Items required in the procedures map contents are missing. Please add and quality check to verify they have been added. A full review will be completed after re submittal. Staff will upload the map contents as a comment for you to verify information.

PALMER - WILLIAMS CREEK WIND/SOLAR ENERGY GENERATION OVERLAY PLAN EL PASO COUNTY, CO

WIND/SOLAR ENERGY GENERATION OVERLAY PLAN
PCD FILE NO.: EA18149
A TRACT LOCATED IN SECTIONS 22, 26, 27, 28, 35, TOWNSHIP 16 SOUTH, ALL IN RANGE 66 WEST OF THE SIXTH PRINCIPAL MERIDIAN, EL PASO COUNTY, COLORADO

|  | <p>WIND/SOLAR ENERGY GENERATION OVERLAY PLAN<br/>         POD EA NUMBER: EA18149<br/>         FILE NUMBER: WSEO181</p> | <p>PRELIMINARY,<br/>         NOT FOR<br/>         CONSTRUCTION</p> | <p>03</p> | <p>Legal Description</p> |

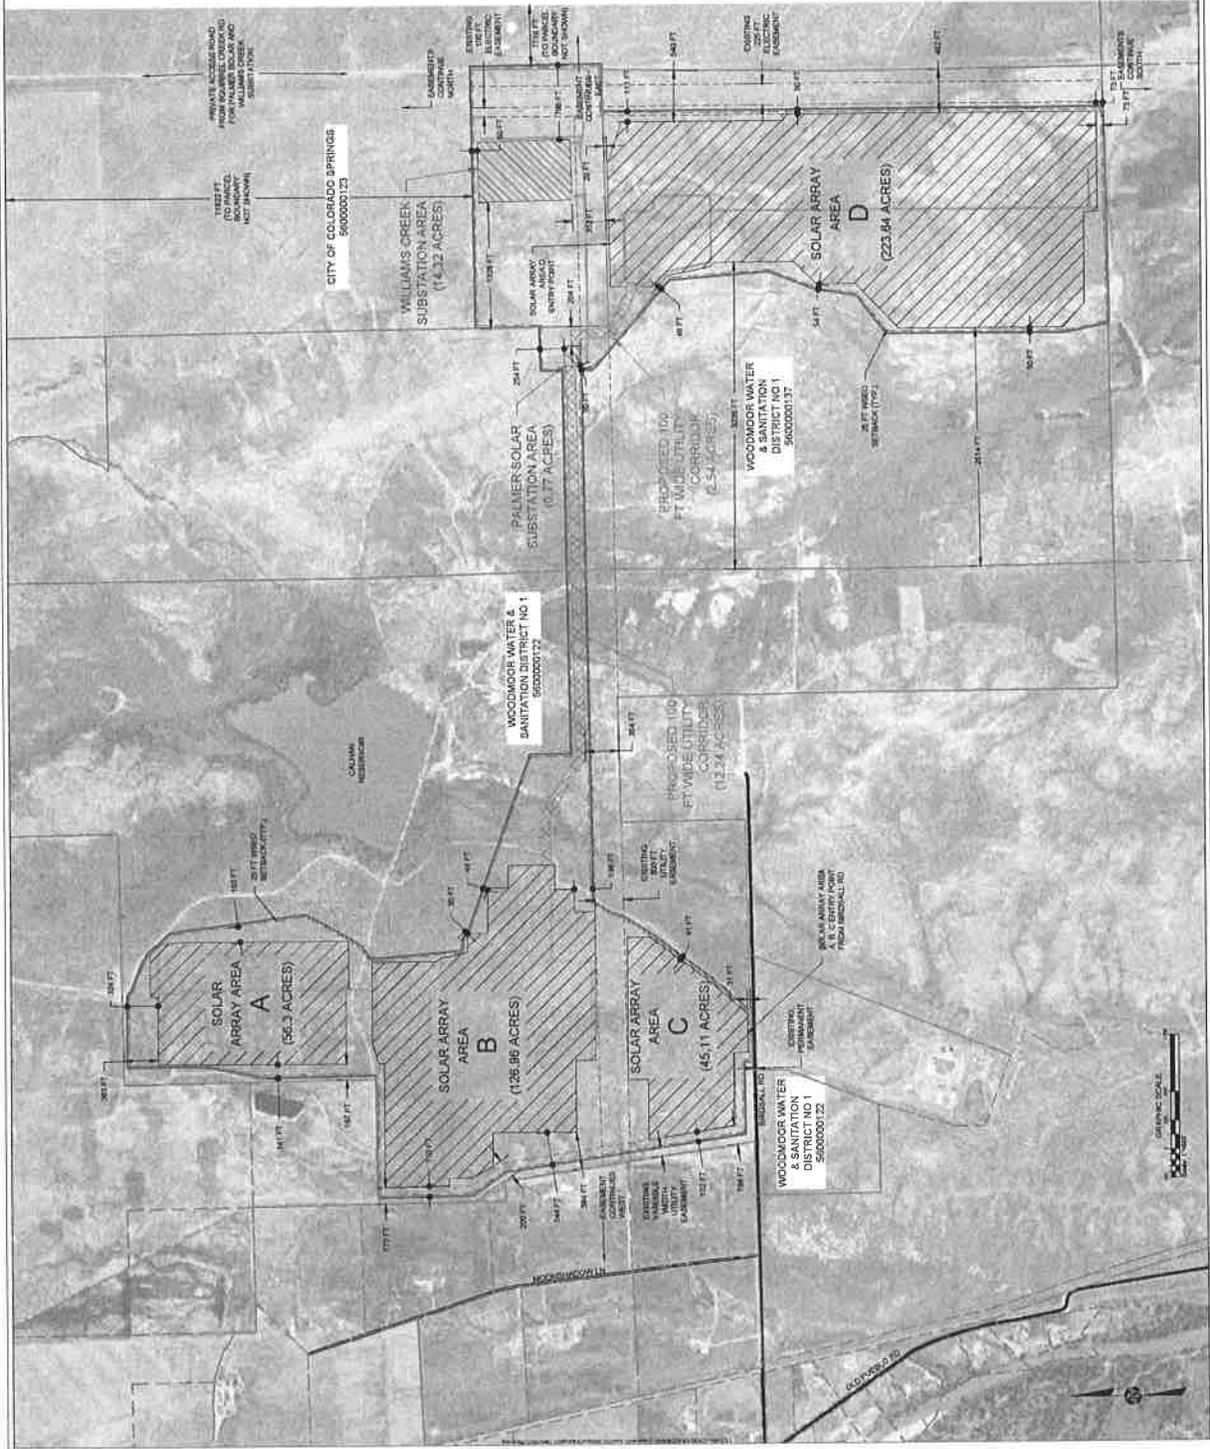
Where is the boundary and depiction as required per the map contents?

The legal needs to be depicted on the WSEO boundary.

The three parcels should be identified within those parcels

DWG TITLE:
WSEO Boundary with
Zoning Overlay

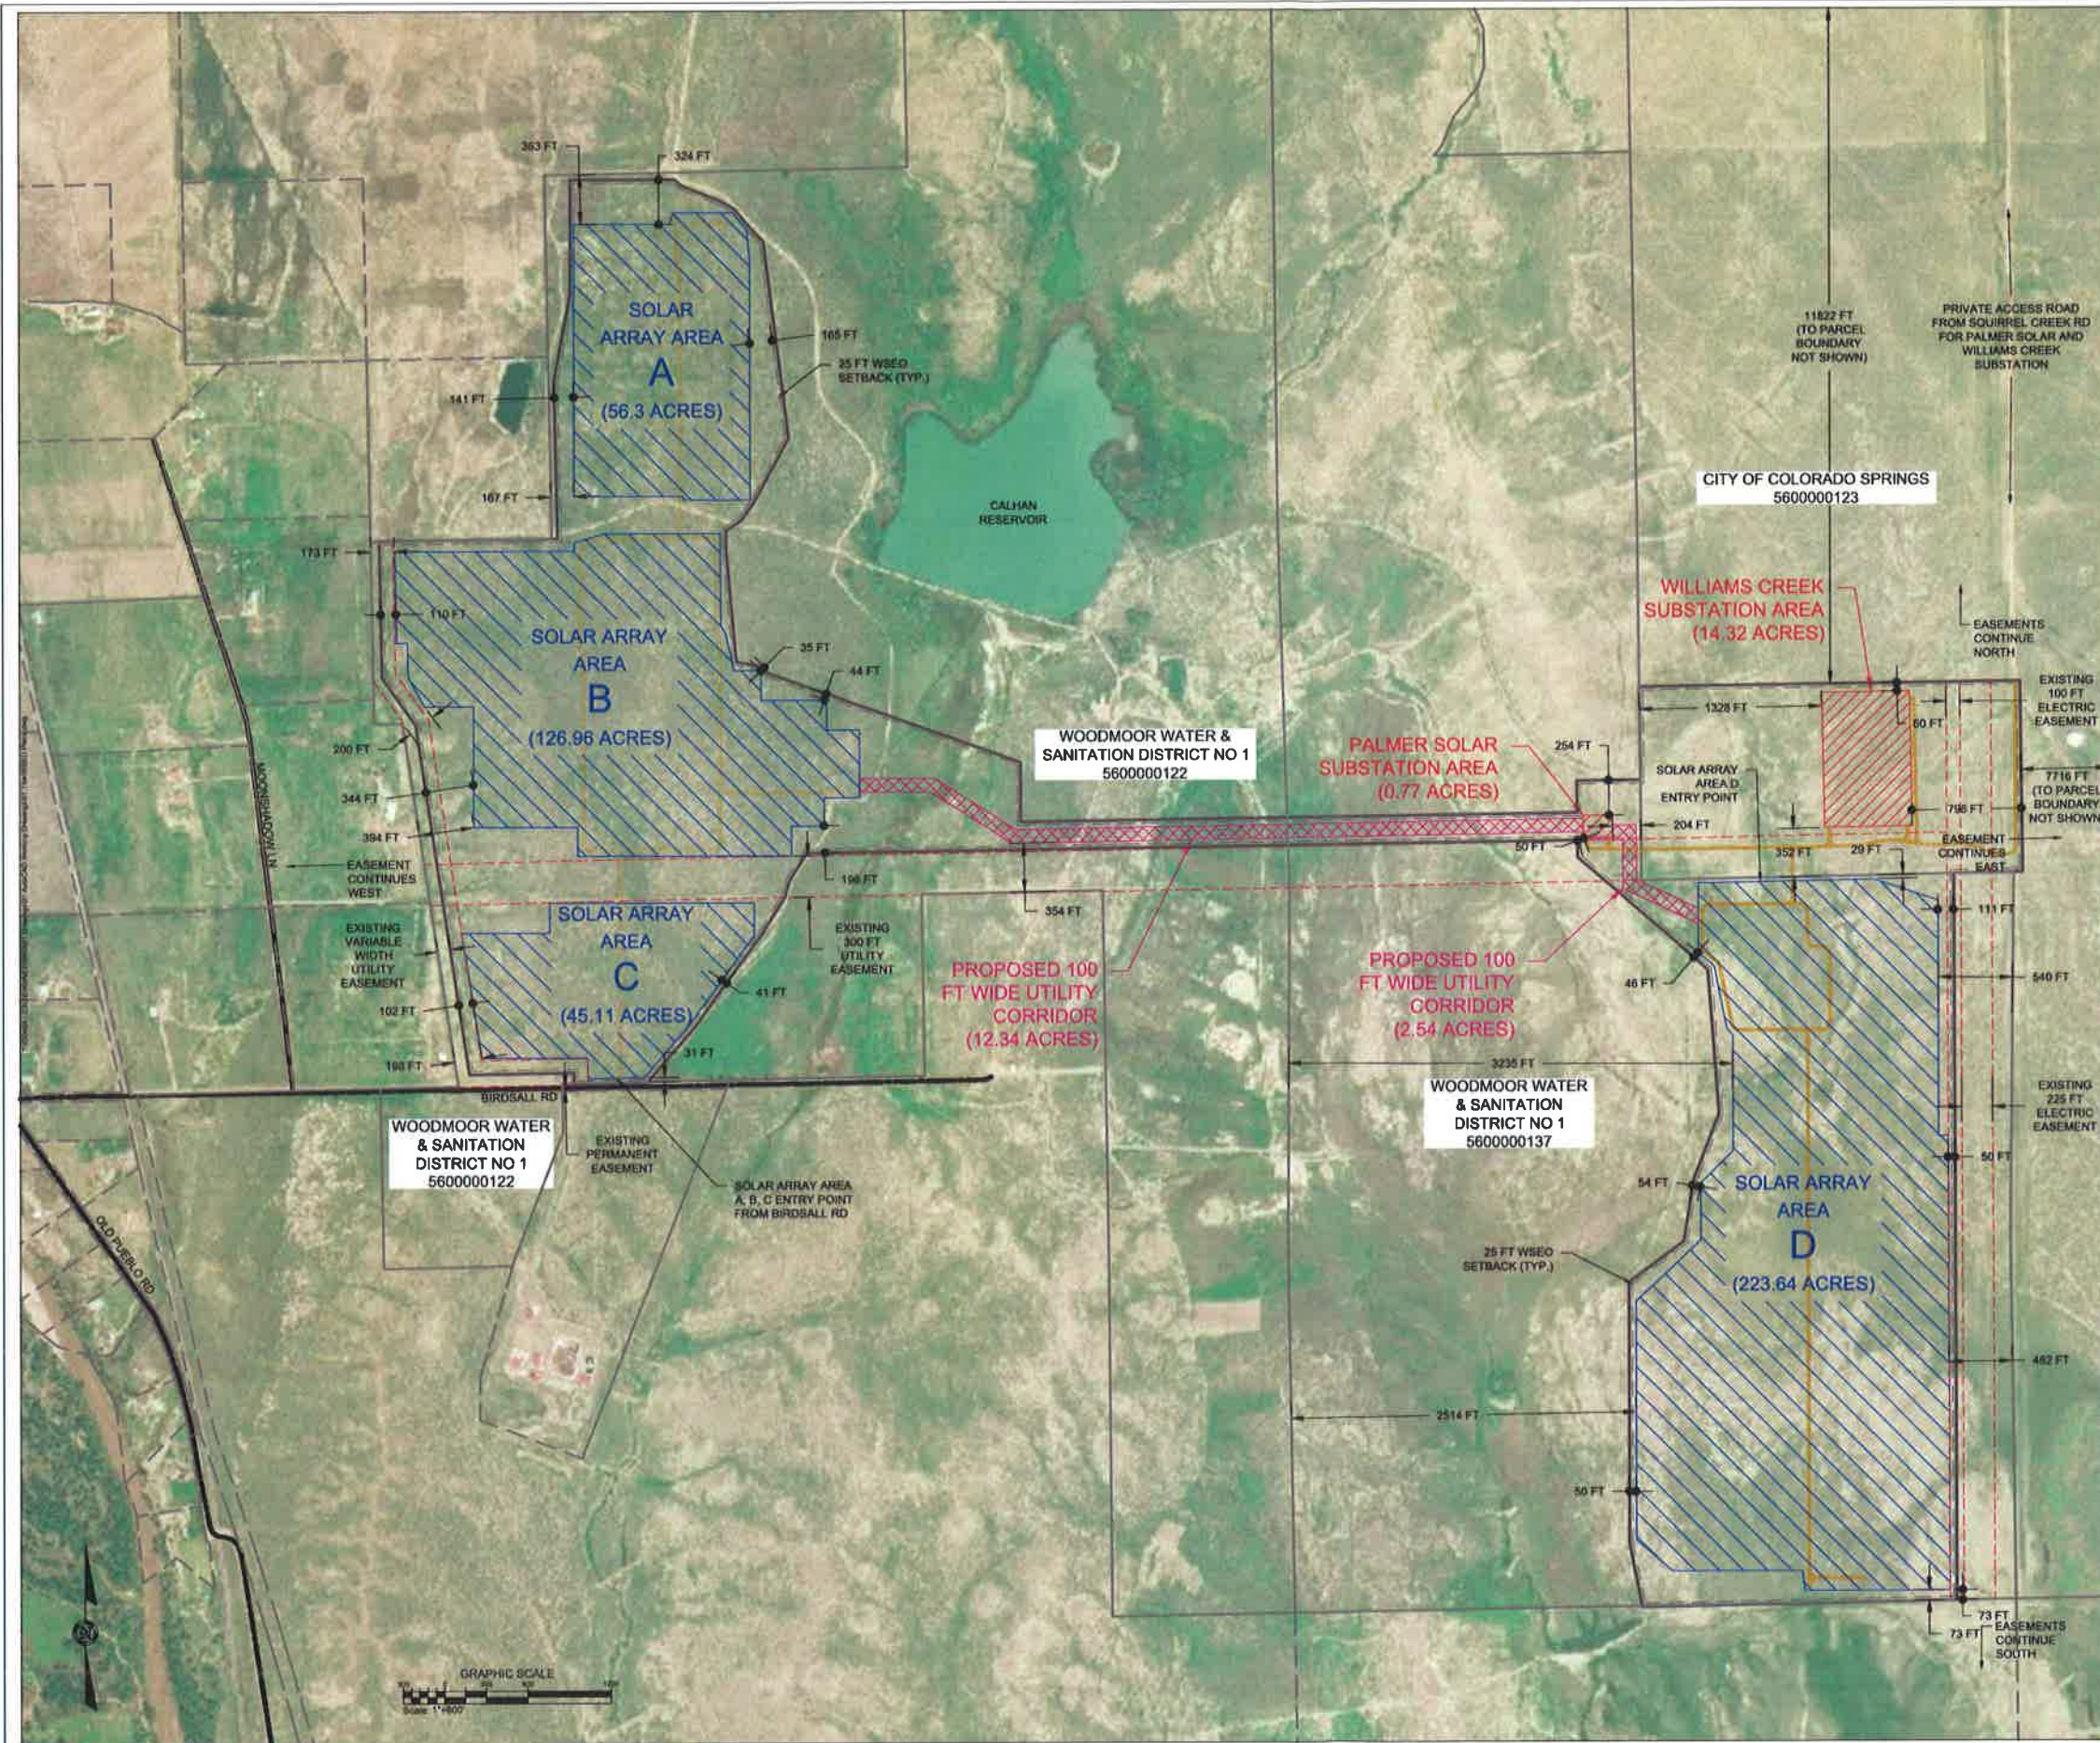
WSEO boundary is identified as the same boundary as the solar arrays? Where are the streams, ponds, floodplains, cultural significance potential areas, and existing and potential roads located? Identify them- they need to be identified per the various studies and imagery here so that we can verify your placement of the facilities components

This map may be appropriate to identify the lines, poles existing and proposed because the latter maps are detailed and it is difficult to see

Property line of parcel? identify all parcel lines that are listed on the application, and label ownership and acreage. Then depict the WSEO boundary with distance and bearing

Identify features within the WSEO boundary
